From: Contact Centre (CRM) <contact@ribblevalley.gov.uk>
Sent: 19 February 2024 14:56
To: Planning
Subject: Planning Application Comments - 3/2024/0042 FS-Case-588129952

Planning Application Reference No.: 3/2024/0042

Address of Development: Land west of Preston Road Longridge PR3 3BE

Elevation

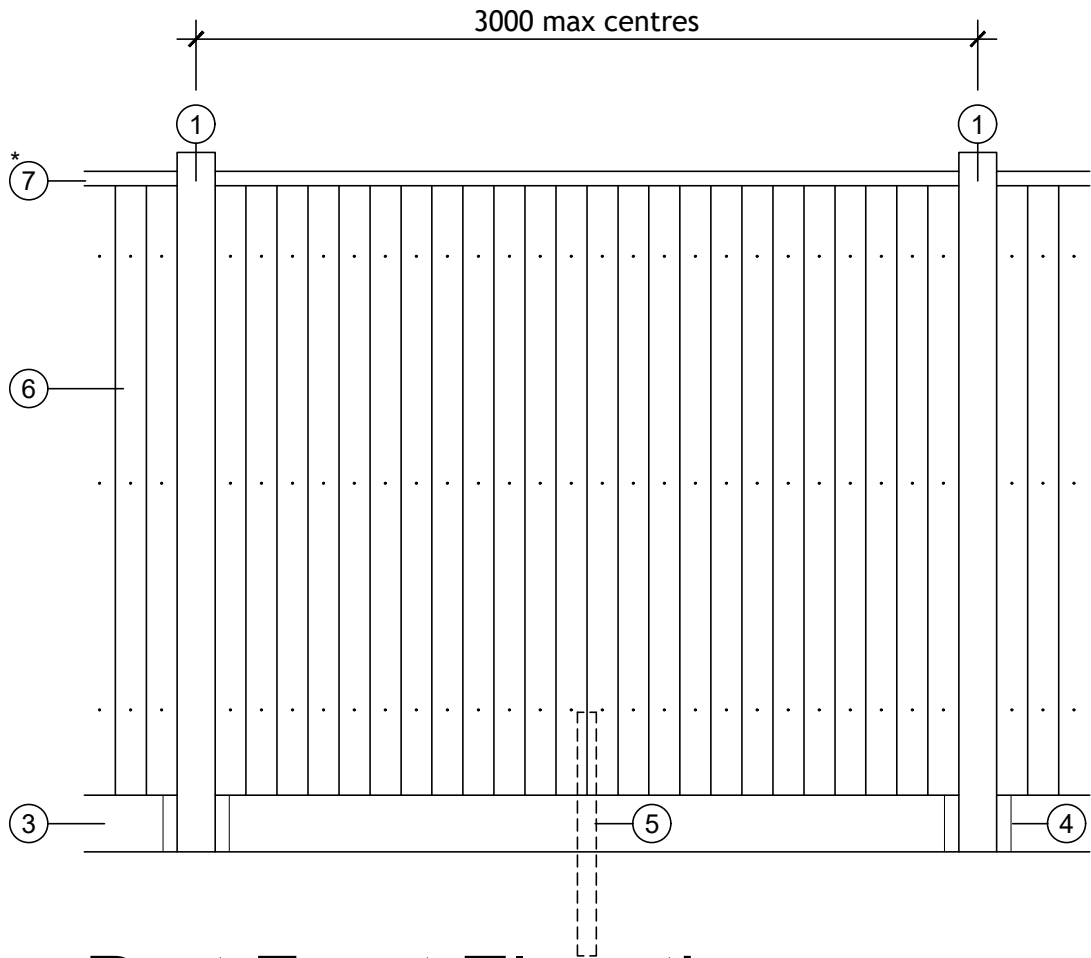
Comments: A new plan has been submitted showing boundary treatments which indicate that the proposed green hedging along Preston Road (from Charnley Fold to the new road junction) has been removed from the plan and replaced with knee rail type fencing. This will leave the grassed area easily accessible by foot traffic for people cutting across the grass rather than walking on the designated tarmac pavements. The hedging would act as a buffer for the road noise created by traffic which is loud at all times of day and night whereas the fencing will offer no sound reducing qualities. On previous planning applications including the initial scheme the boundary at this point was always shown as having the existing trees, hedges, and vegetation retained but since this has been removed it surely must be reinstated back to original condition in accordance with the original planning permission, this will reinstate some of the wild habitat back for birds, animals, insects etc
